Marge Schmuckal - 83 Shepherd Lane application

From: Marge Schmuckal
To: samgile@gmail.com
Date: 7/8/2013 11:58 AM
Subject: 83 Shepherd Lane application

#2013-01389
351-B-009

PLOT PLAN

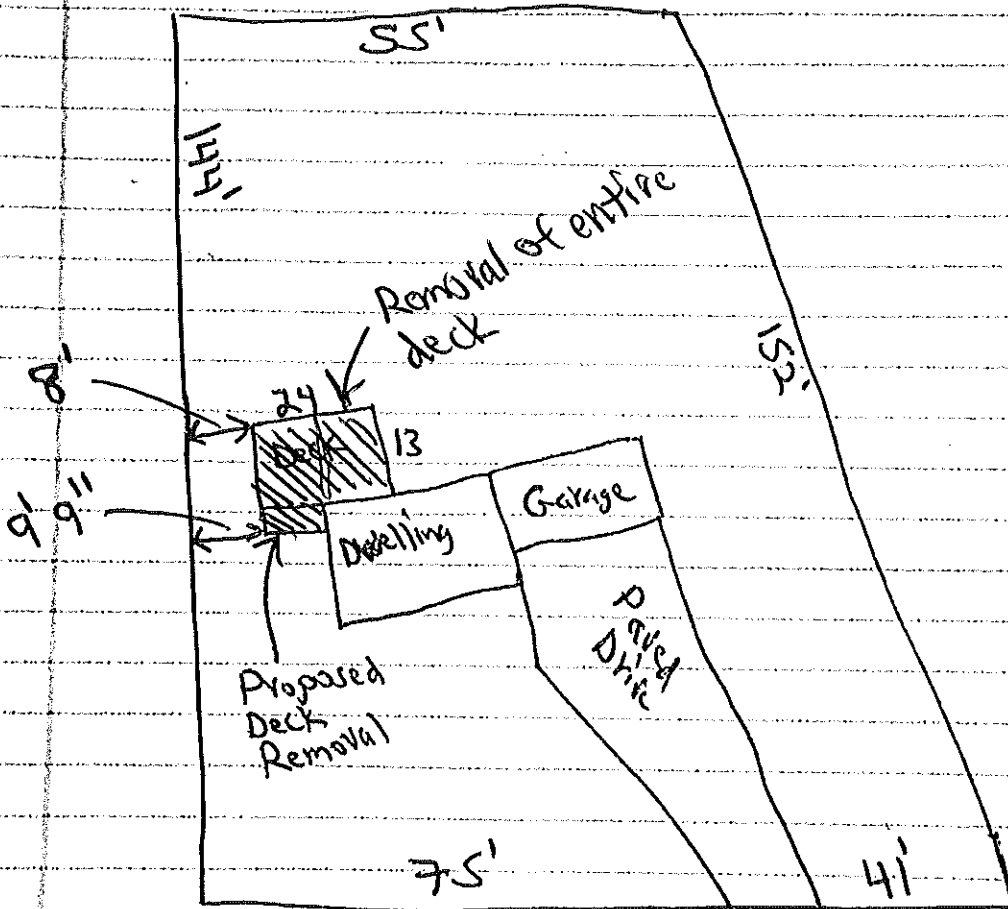
Please note that your permit application to remove a portion of your rear deck is being approved. However, please note that our files indicate that the entire deck was never properly permitted and does not meet the R-2 Zone required setbacks. The R-2 Zone requires a 12' side setback [14-80(d)3] instead of the 8' at the closest point that you have shown us in your application.

You must legalize your deck by either removing it by permit, removing a portion of it by permit to meet the R-2 setbacks or you have the right to appeal. If you wish to exercise your right to appeal, you have 30 days from the date of this letter (7/8/2013) in which to appeal. If you should fail to do so, my decision is binding and not subject to appeal. Please contact this office for the necessary paperwork that is required to file an appeal.
